Application for a Minor Material Amendment following a grant of planning permission FG/33/10/ for minor alterations to elevations of building, including lobby, energy centre & plant. Minor alterations to car park layout, landscaping & surface materials (this application also falls within the parish of Angmering)

Country Fayre Littlehampton Road Ferring

Thank you for your internet comments made on 13th March 2012 and recorded as follows:

TITLE
Asda Ferring
Proposed Ground Floor Plan

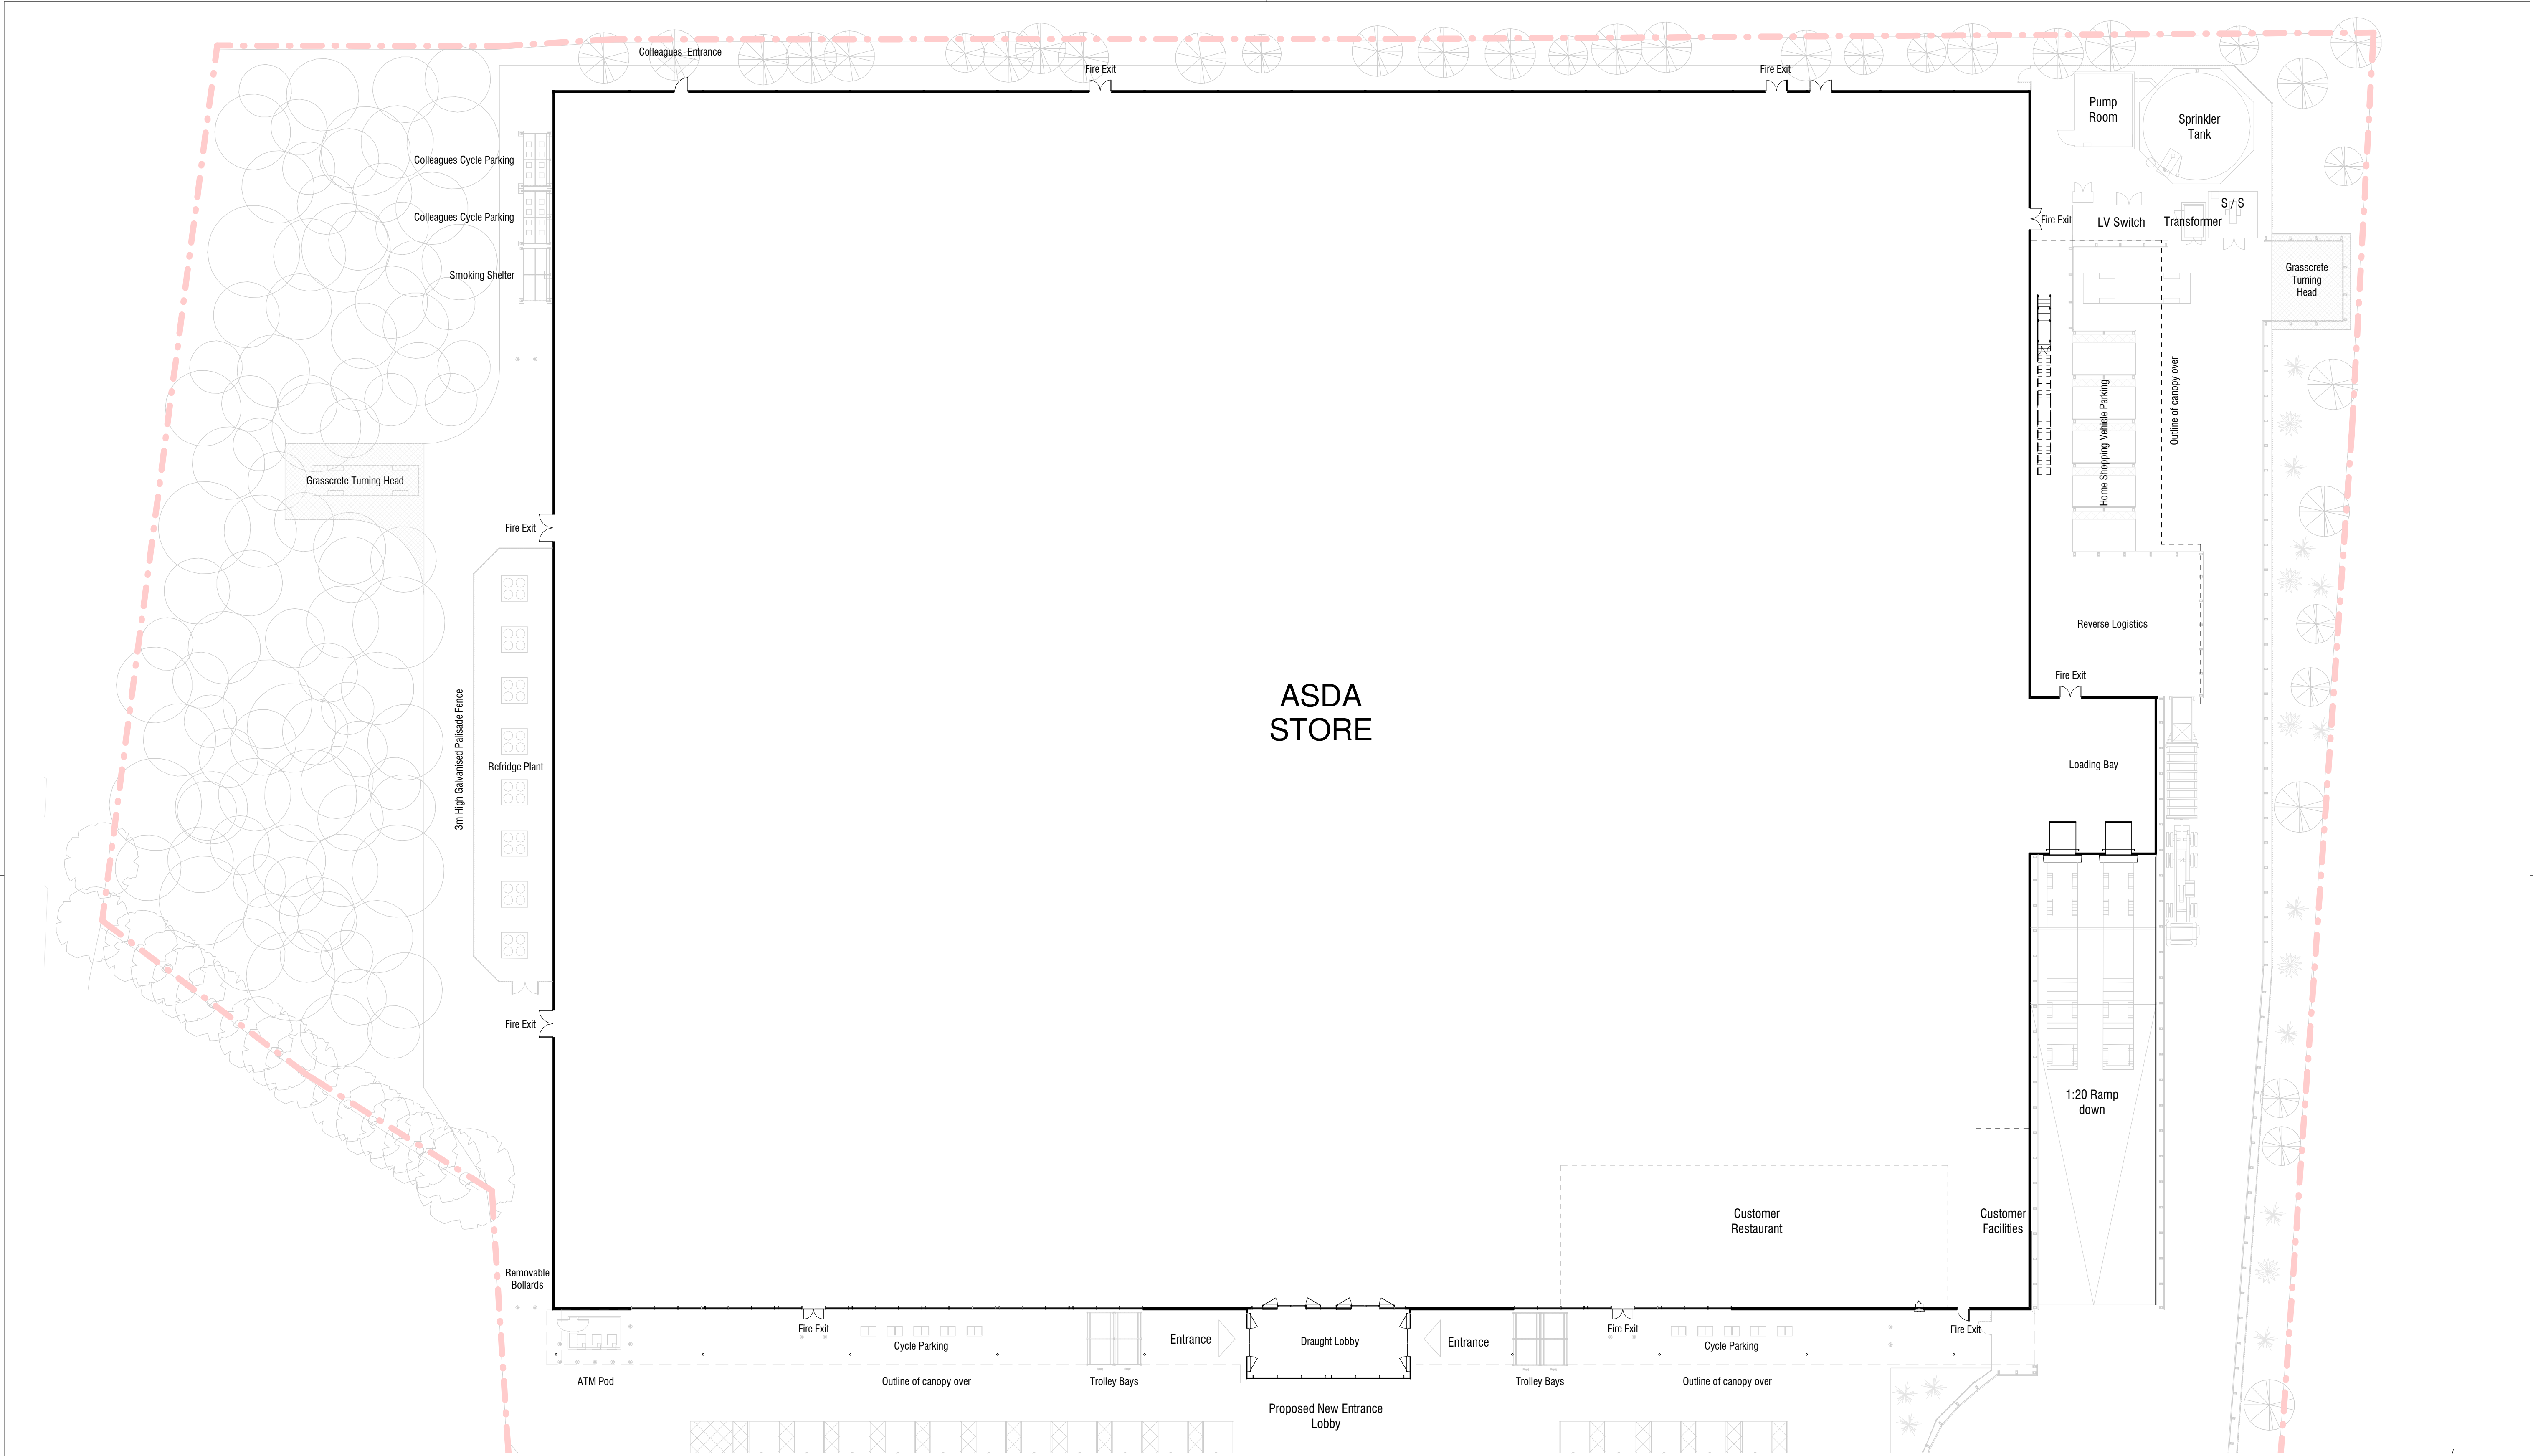
Lobby Area - this appears to be a potential increase in floor space as set down in Condition 3 of the Decision Notice and therefore the Parish Council objects.

Proposed Roof Plan

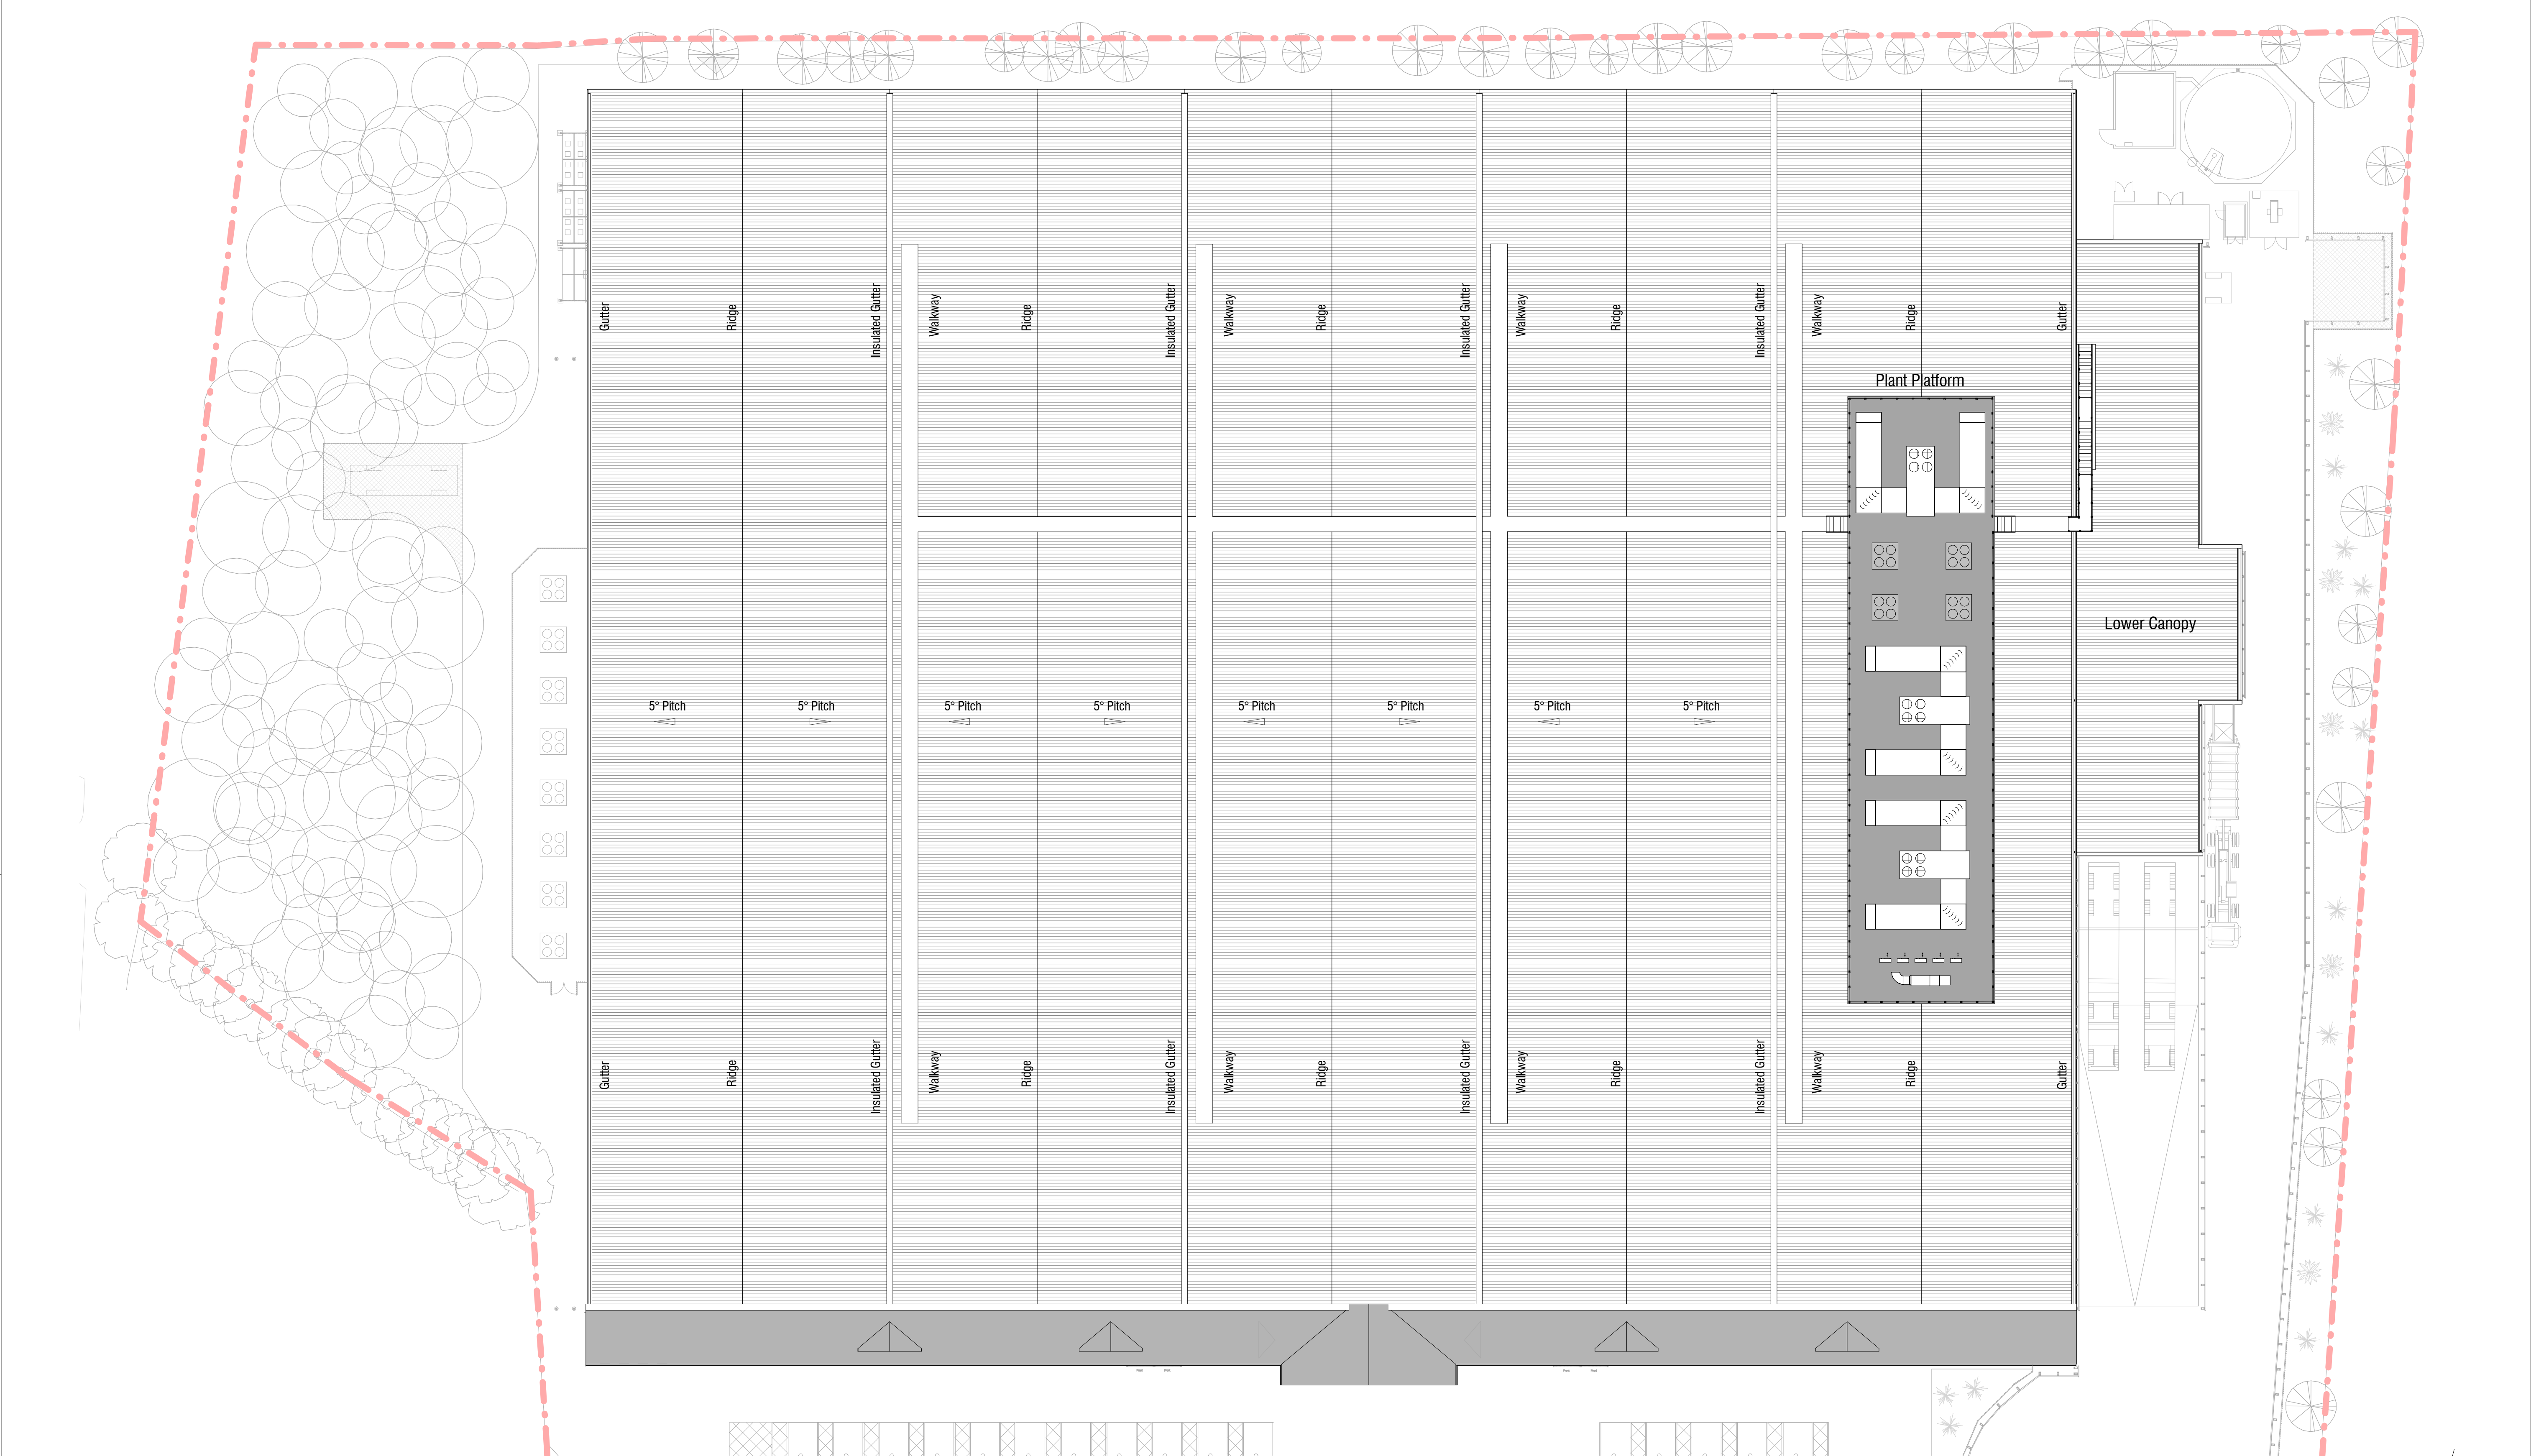
Energy Centre and Rooftop Plant - whilst the proposal to relocate rooftop plant to ground level is welcomed, there is no information about the potential noise levels of the refrigeration and air conditioning units which will presumably run 24/7. Until such time as technical data shows that this will not interfere with the quiet enjoyment of the properties close to the site, the Parish Council objects to this.

TITLE
Asda Ferring
Proposed Site Plan

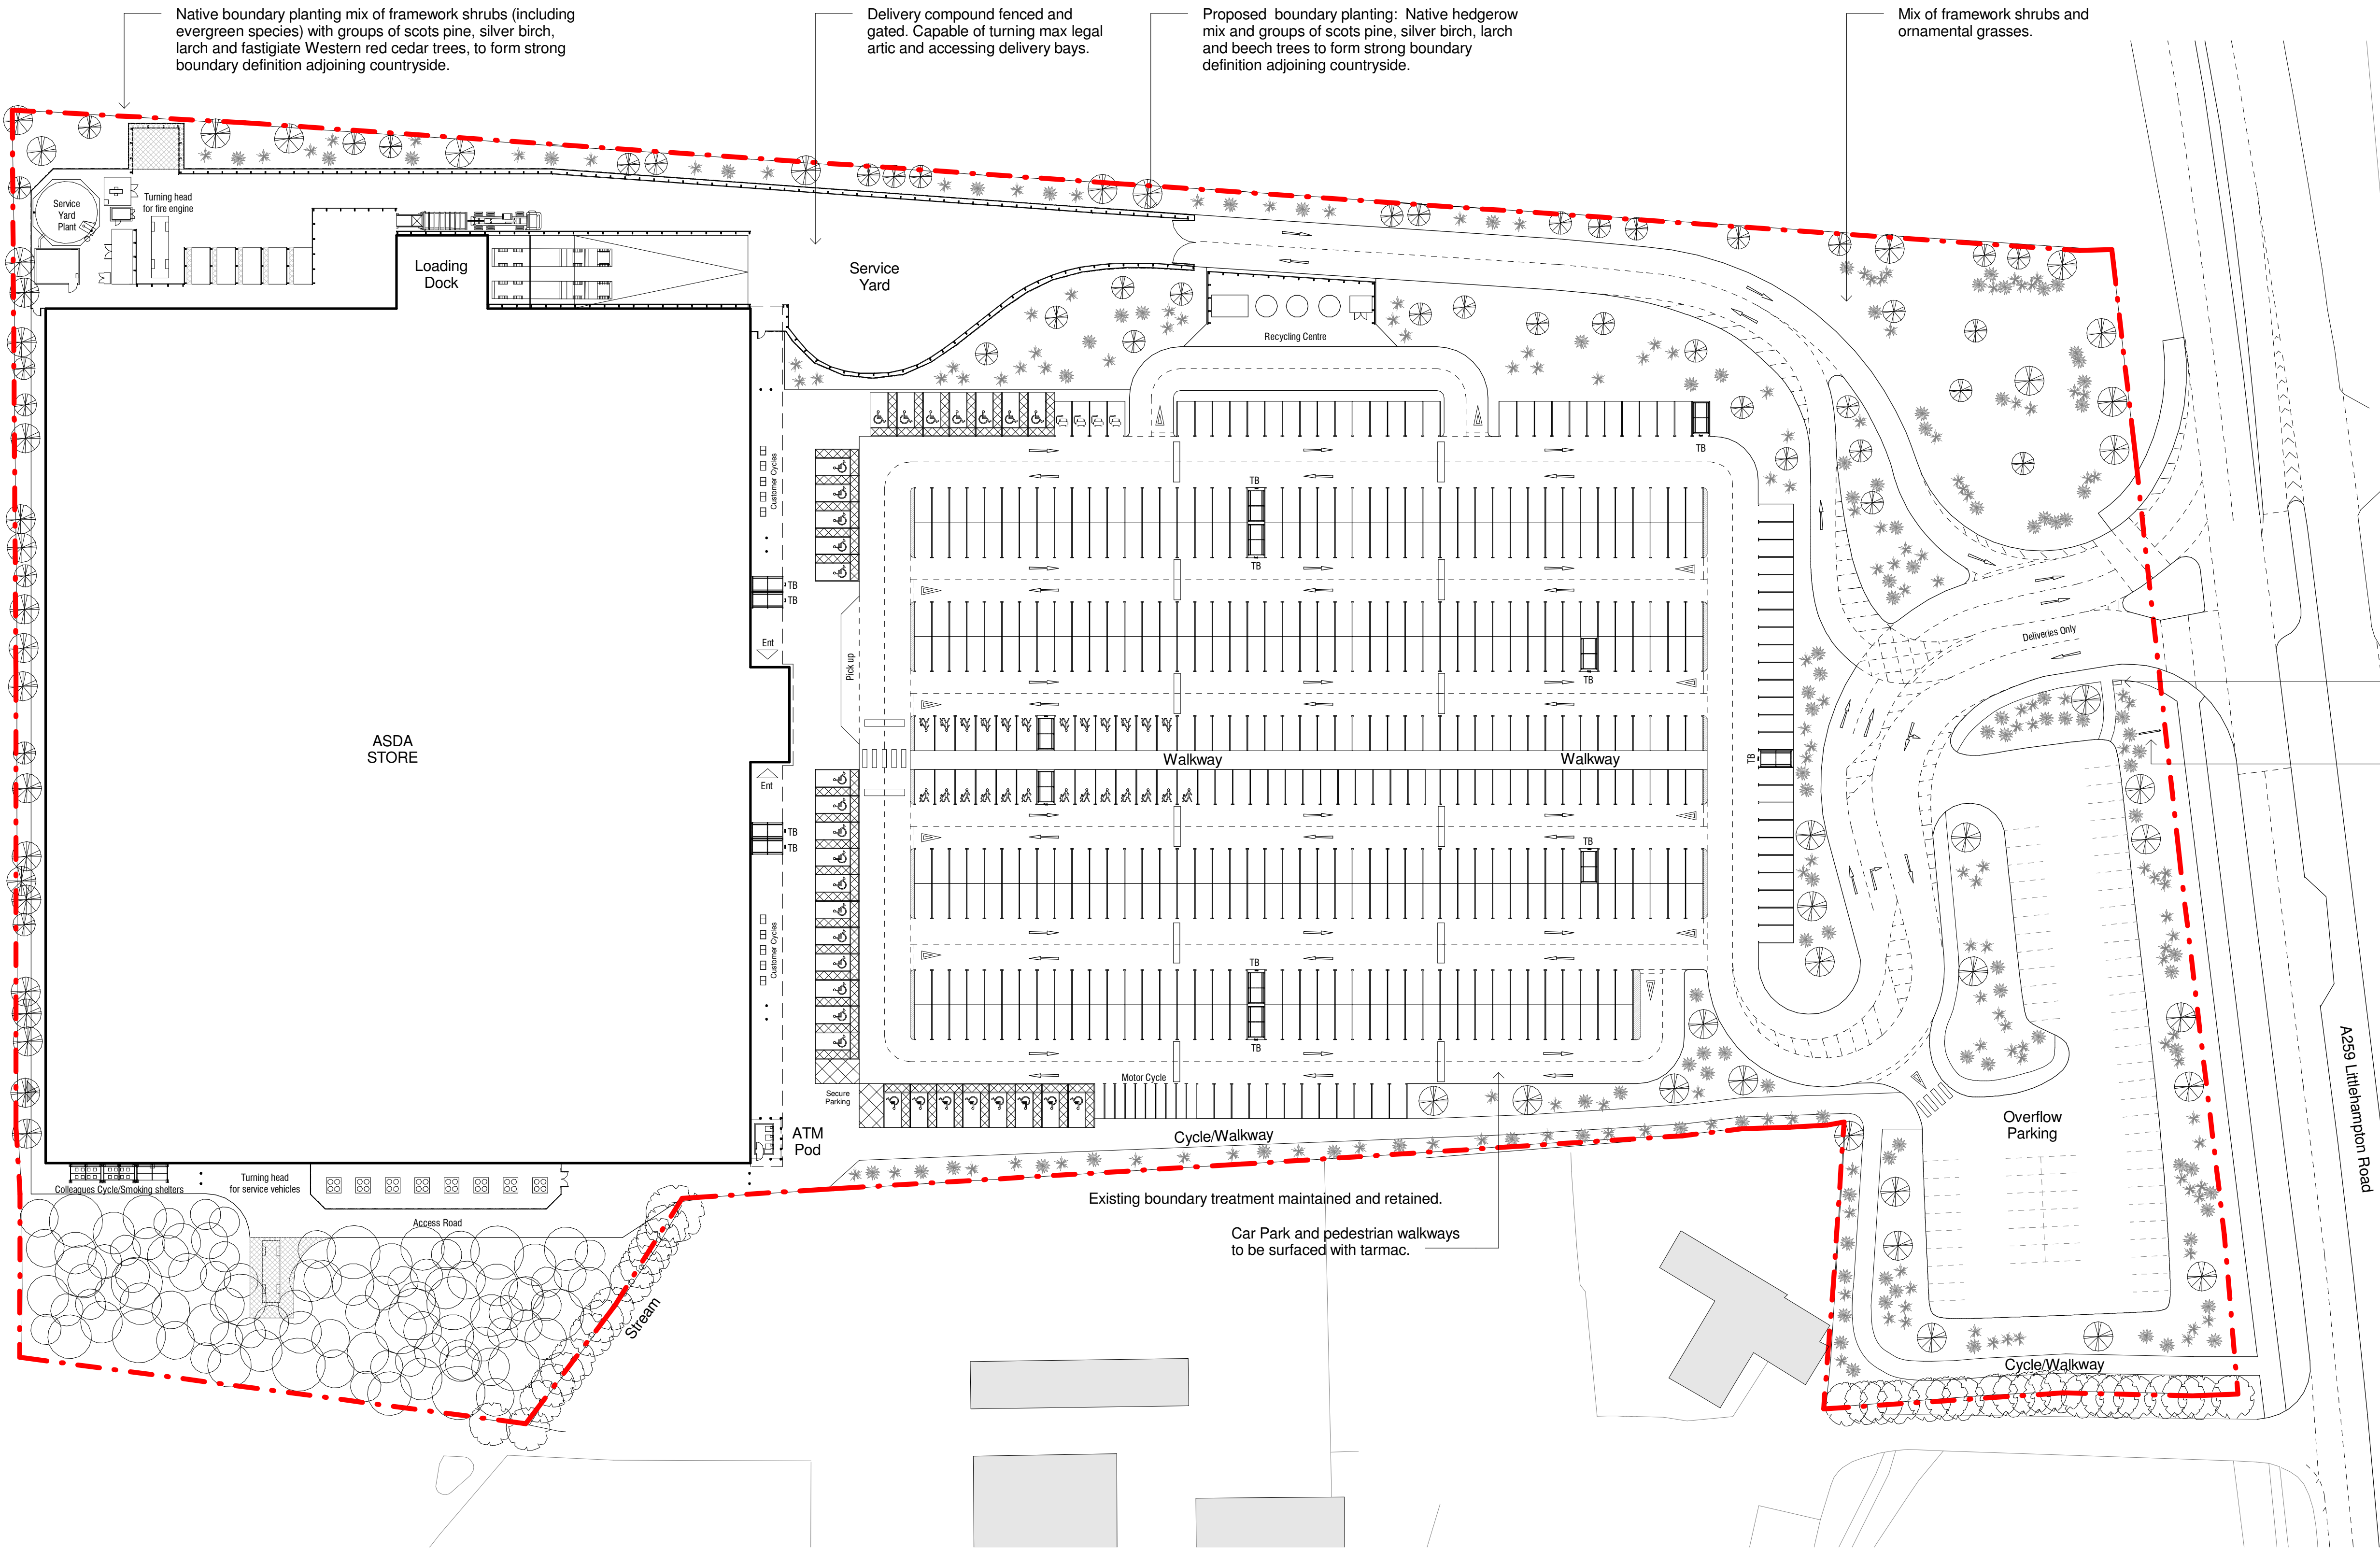
Enhanced Landscaping - we welcome the enhanced landscaping but object to the use of beech trees as it is felt these would be unsuitable for this site due to their slow growth and shallow root system.
